**Final Acceptance Punchlist**  
**El Paso County – Department of Public Works - Stormwater Section**

Project Name:	Redtail Ranch
EDARP Filing Number(s):	SF1821
ESQCP Number:	ESQ1932
Attendees:	DPW SW: Molly Layshock, Mikayla Hartford, Glenn Reese DPW Dev Services: Developer:
Date of Walk-Thru:	05/18/2023
Walk-Thru Number:	1 <sup>st</sup> FA walk

\* UPON GRUBBING EXISTING SOILS IN EMBANKMENT AREA, ENGINEER SHALL BE CONTACTED TO DETERMINE SOIL QUALITY. IF POOR PERMEABILITY IS FOUND (I.E. SANDY-SILT) ONLY TOP 2' X 14' PORTION OF EMBANKMENT KEY IS REQUIRED FOR CONSTRUCTION.

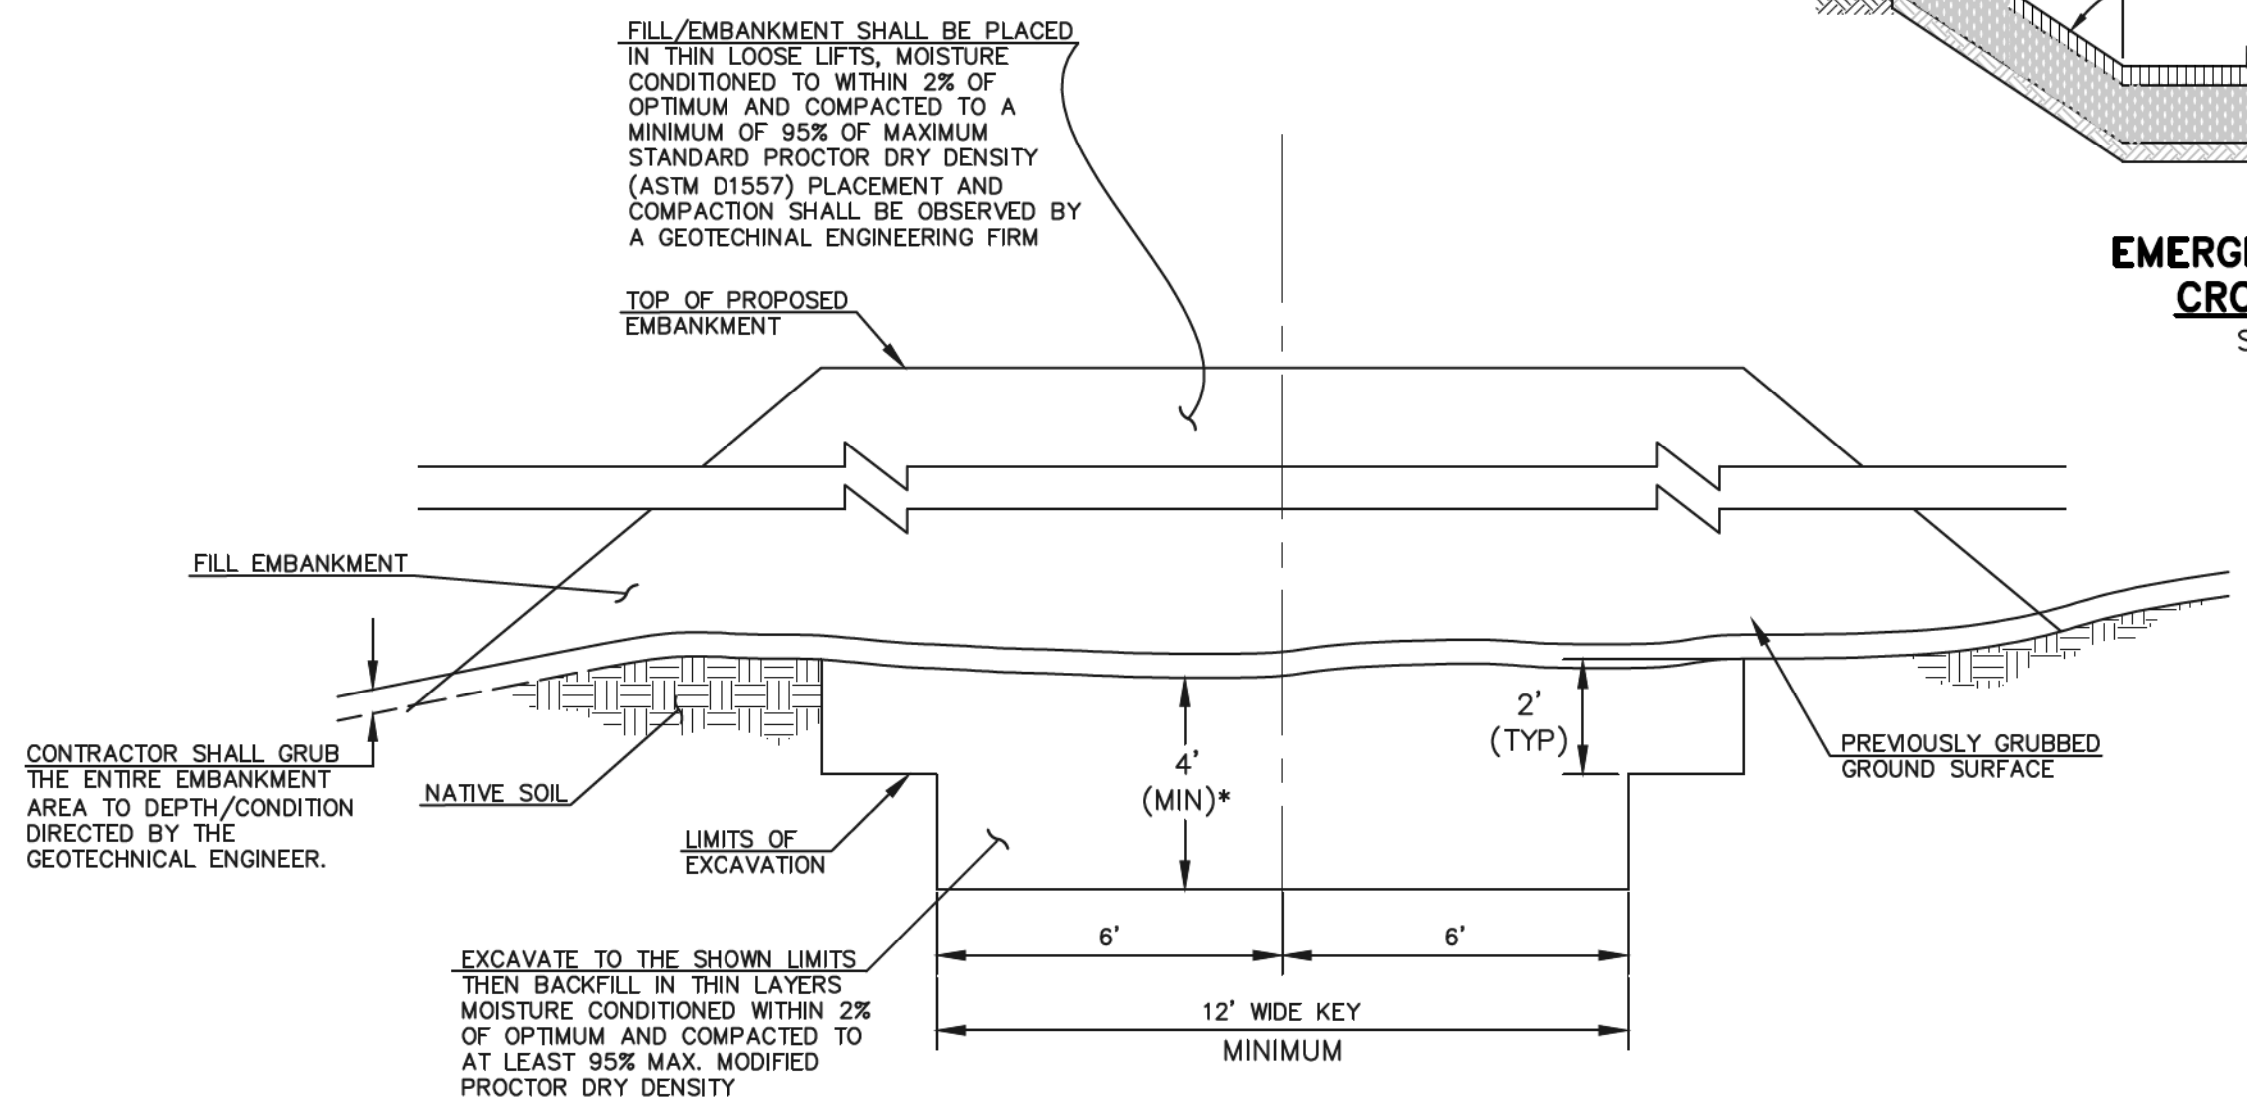
- Add white 1.5" PVC pipe to as-builts (See comments on as-builts)
- Missing rock check dam off of Sanctuary Pine Drive. Need to install per plan detail EC-12 on sheet 2 or show change on as-builts (See comments on as-builts)
- Remove debris from pond forebay
- Raise pond bottom to top of trickle channel curb with a 3% slope towards trickle channel for positive drainage
- Address shoulder riling along forebay

- Update as-builts to change soil riprap called out on sheet 10 of the plans to be riprap reflecting the change observed in the field. (See comments on as-builts).
- Clean out sediment from the outfall pipe flared end section, it is holding water
- Wrong well screen is installed in the field. Install proper well screen, diamond well screen is not permitted.
- Downstream of the outlet: remove rock socks from in front of the culvert under Vollmer Road. Regrade so that no ponding occurs. All temporary control measures must be removed prior to FA. (See photo 3)
